Application no: 23/01031/DISC

Location: Axis J9 Phase 3, Howes Lane, Bicester

Transport Development Control

This application is to discharge condition 6 for the footway/cycleway link between the site and Howes Lane. The path will link to a new toucan crossing on Howes Lane, which is the subject of a S278 application to OCC, whereby the detail will be agreed.

Drawing Title
**Access Road (Phase 3)
Link Path Details**

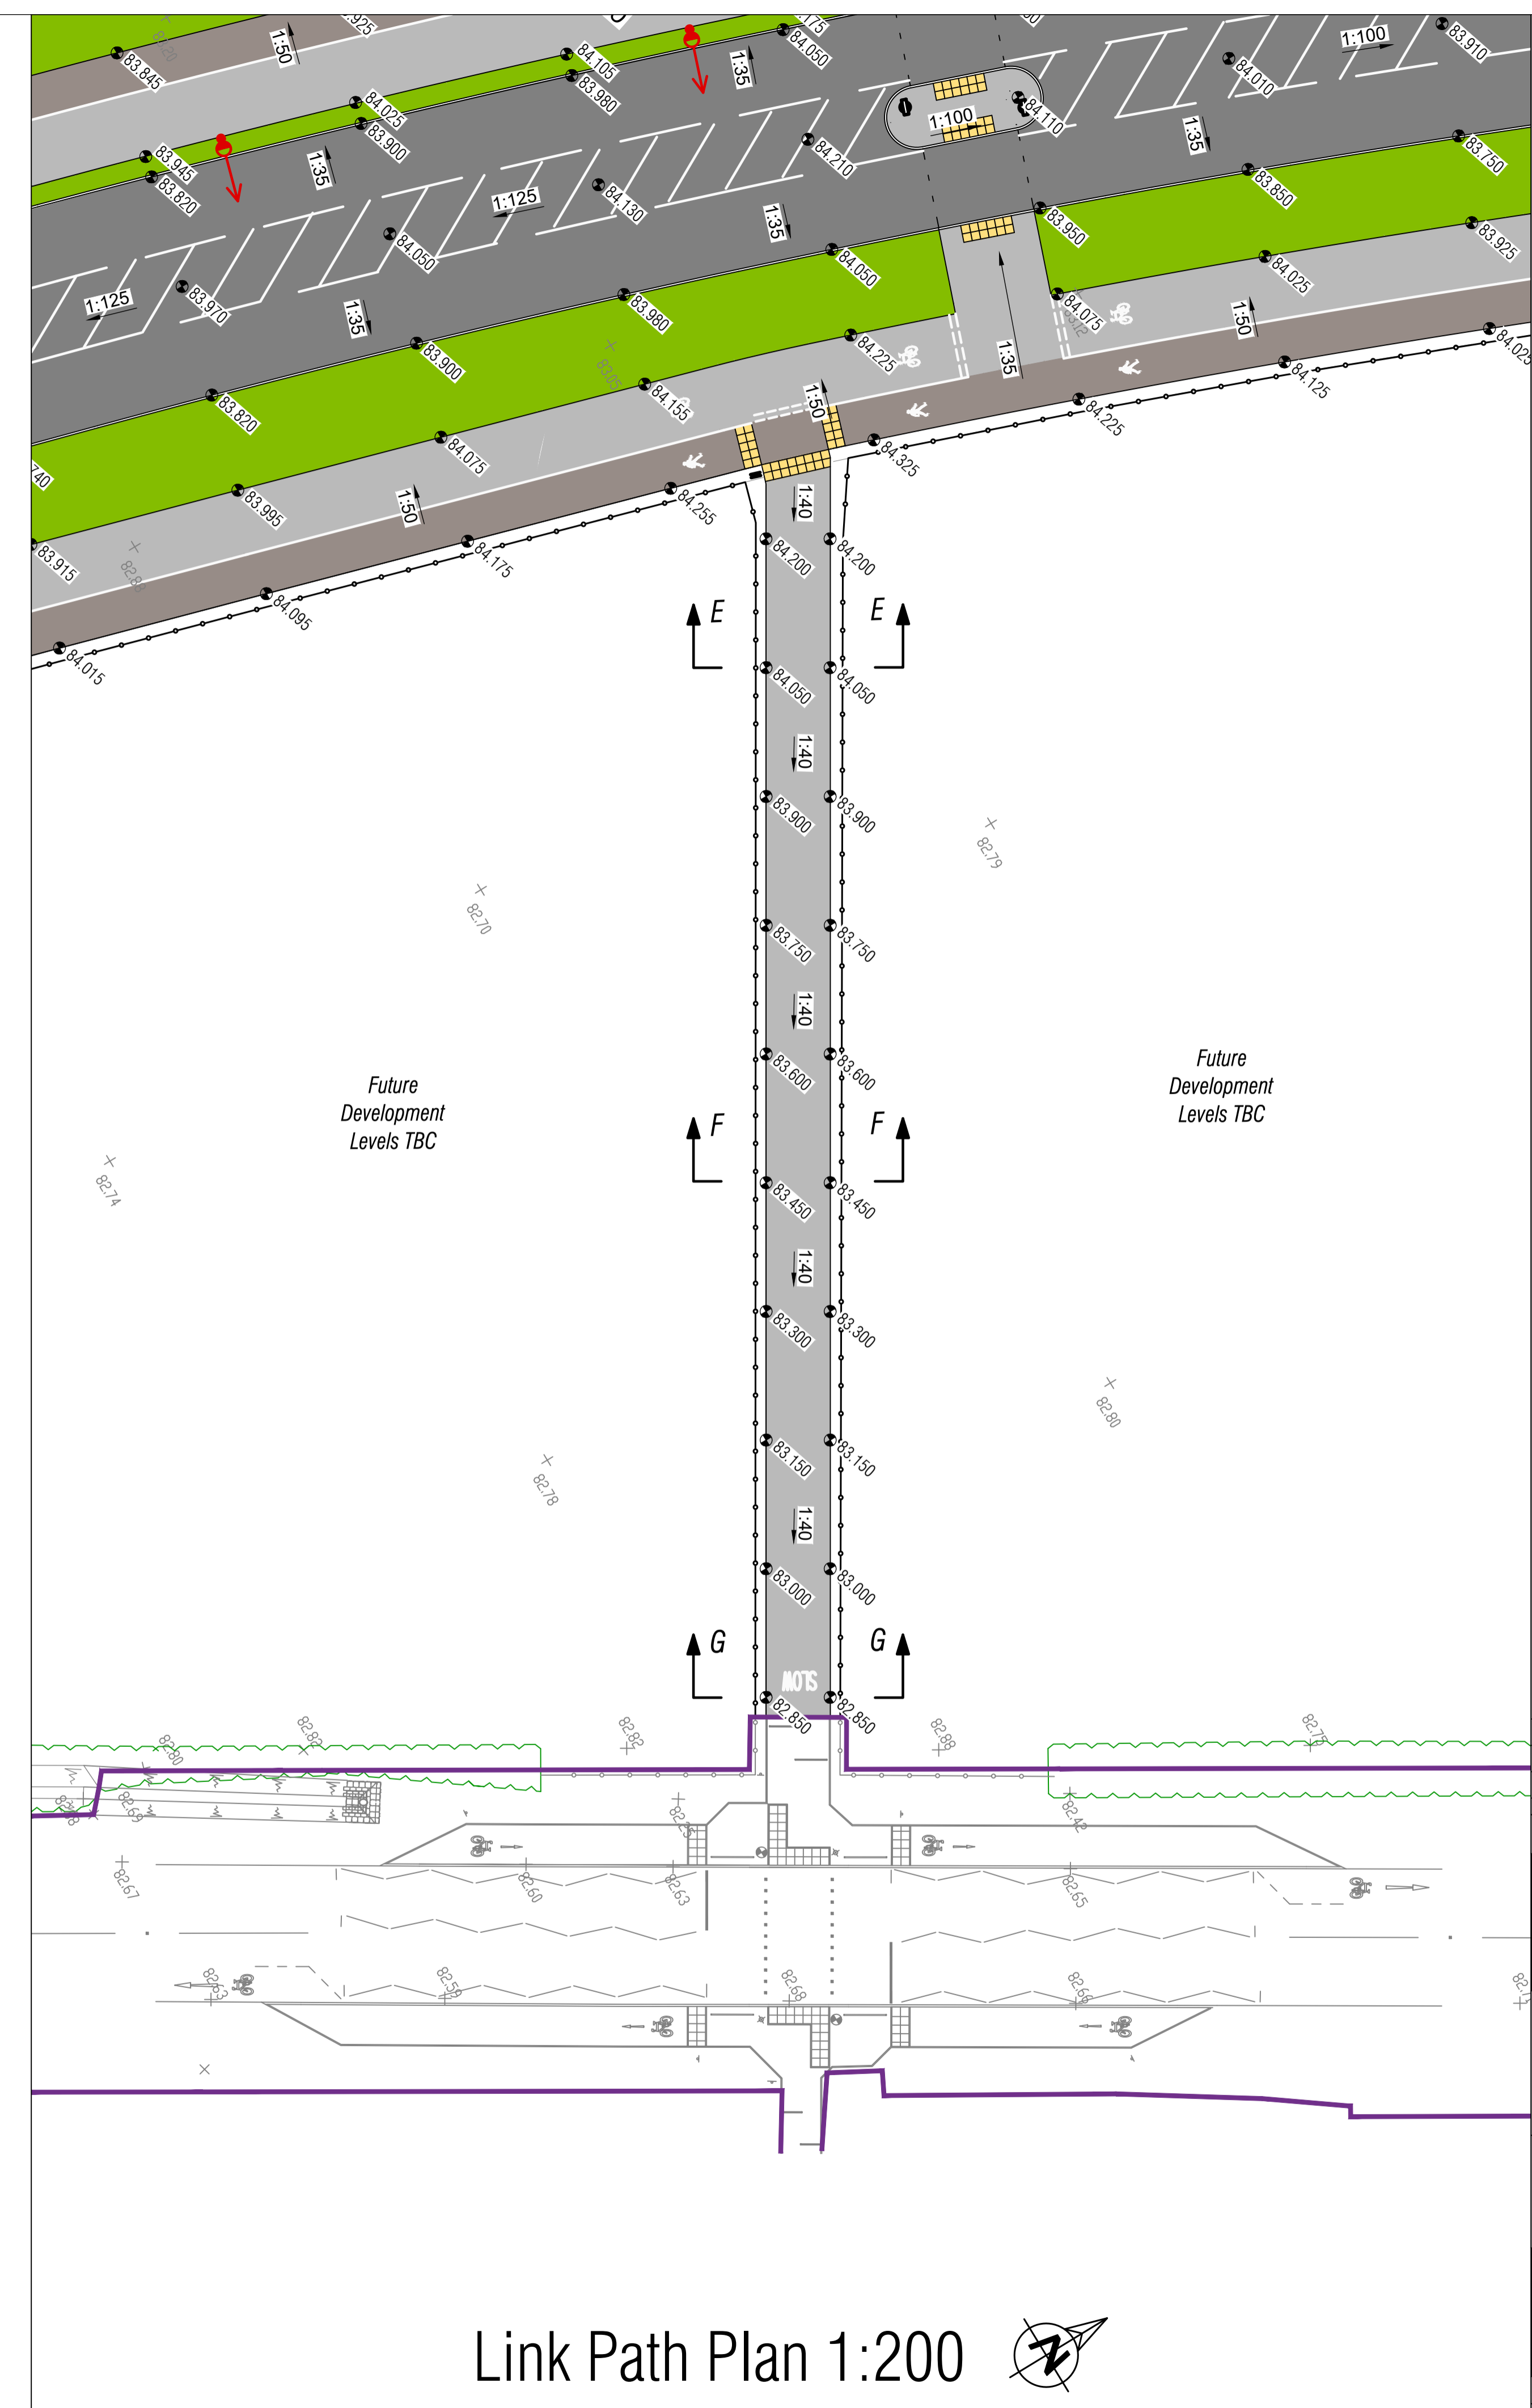
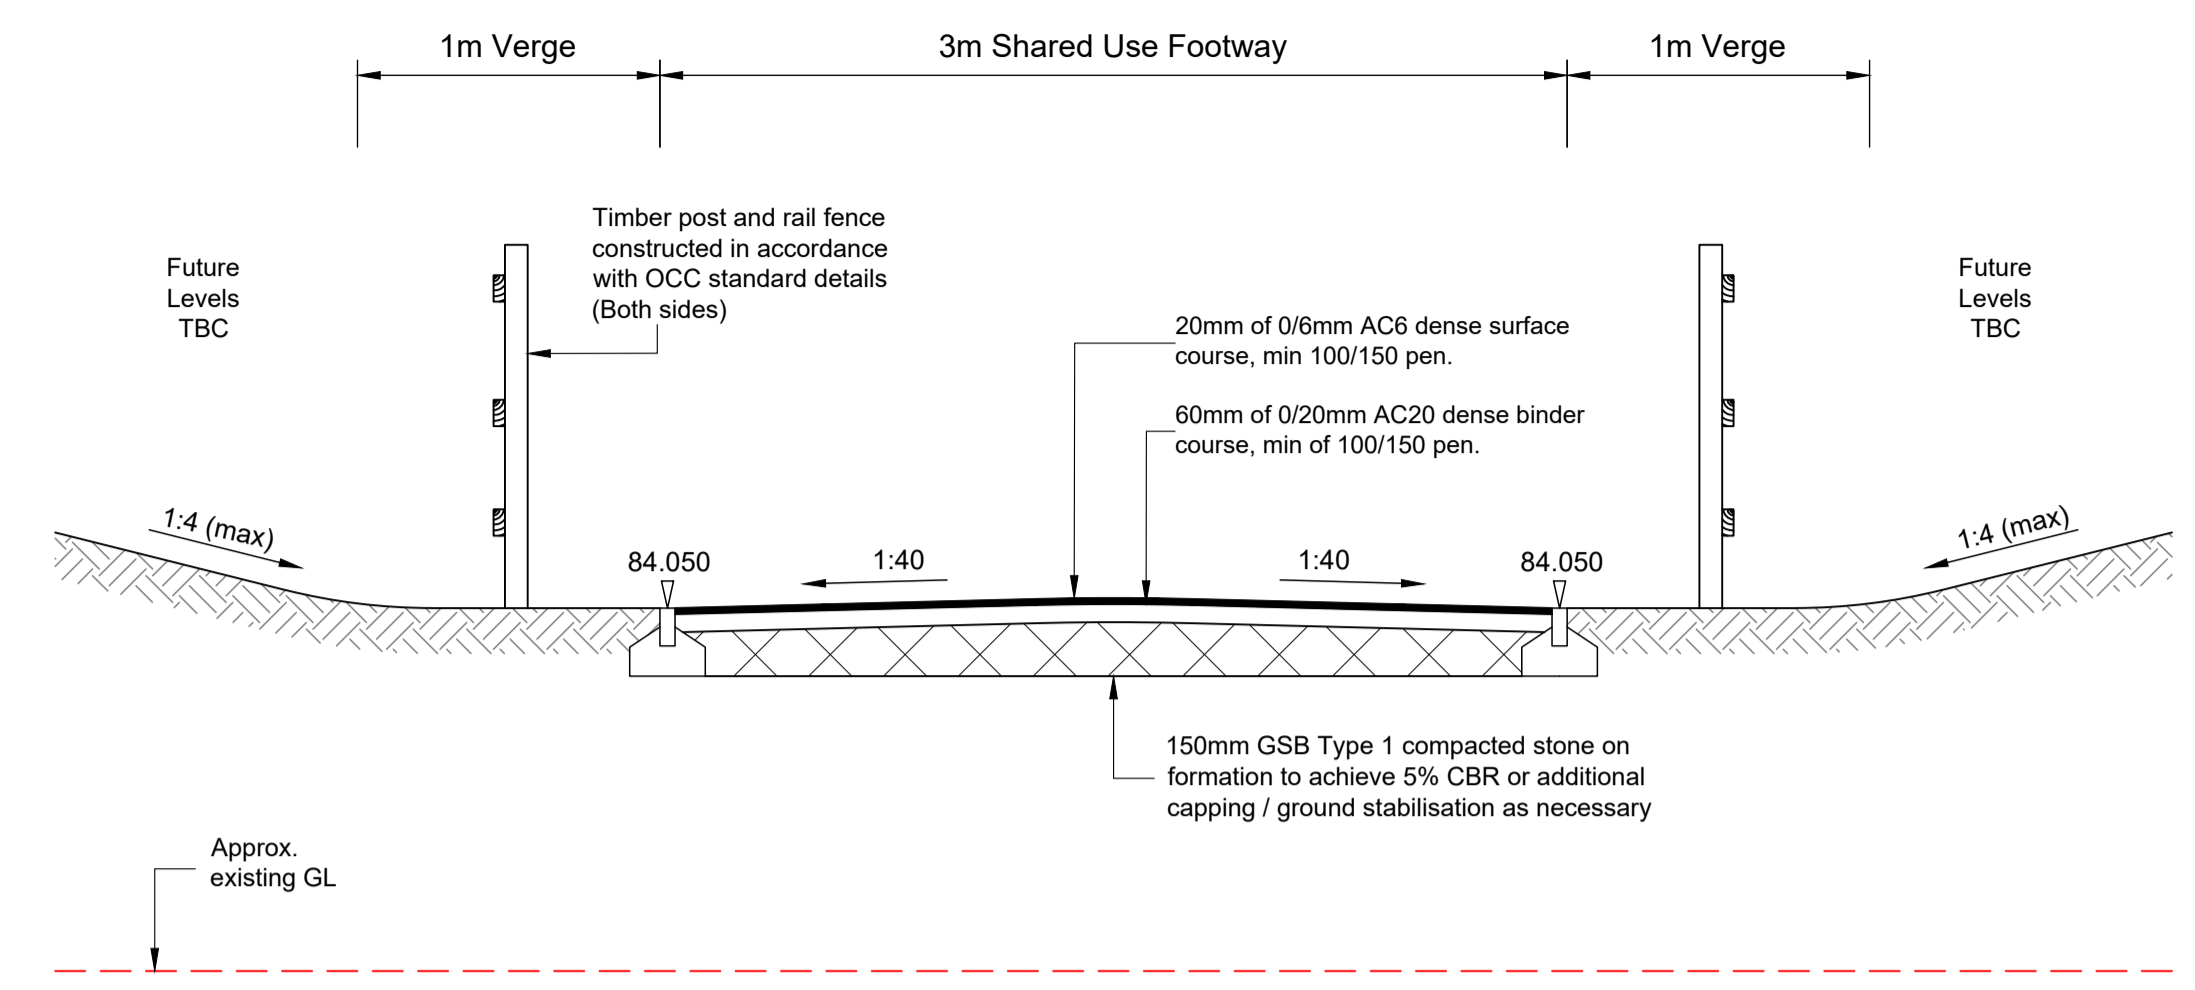
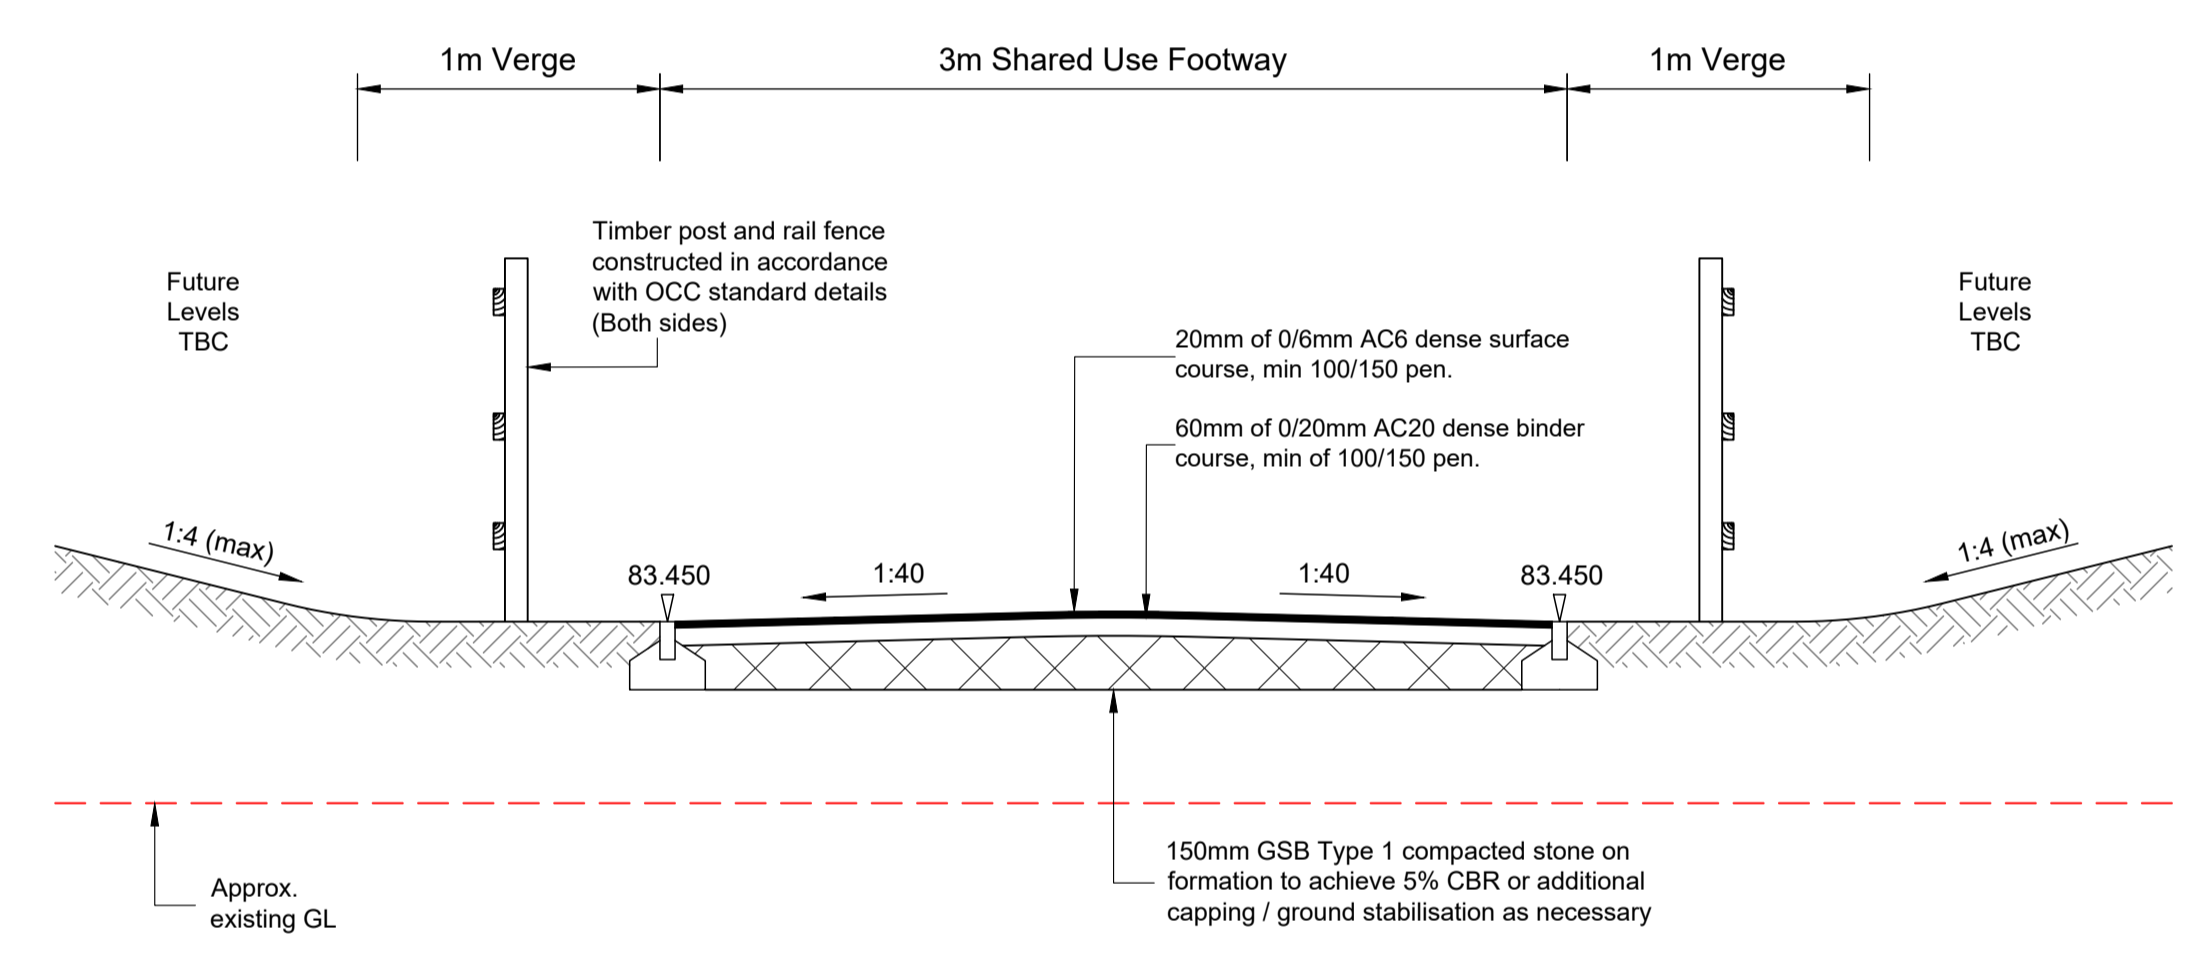
It's assumed that this path will be part of a S38 submission, whereby the technical detail will be agreed. However, it is acceptable in principle. The path is proposed as a 3m wide shared use path, which is in line with the planning permission and acceptable here as in the longer term the path will have a relatively low level of usage, the main route being provided via the paths alongside the new strategic link road.
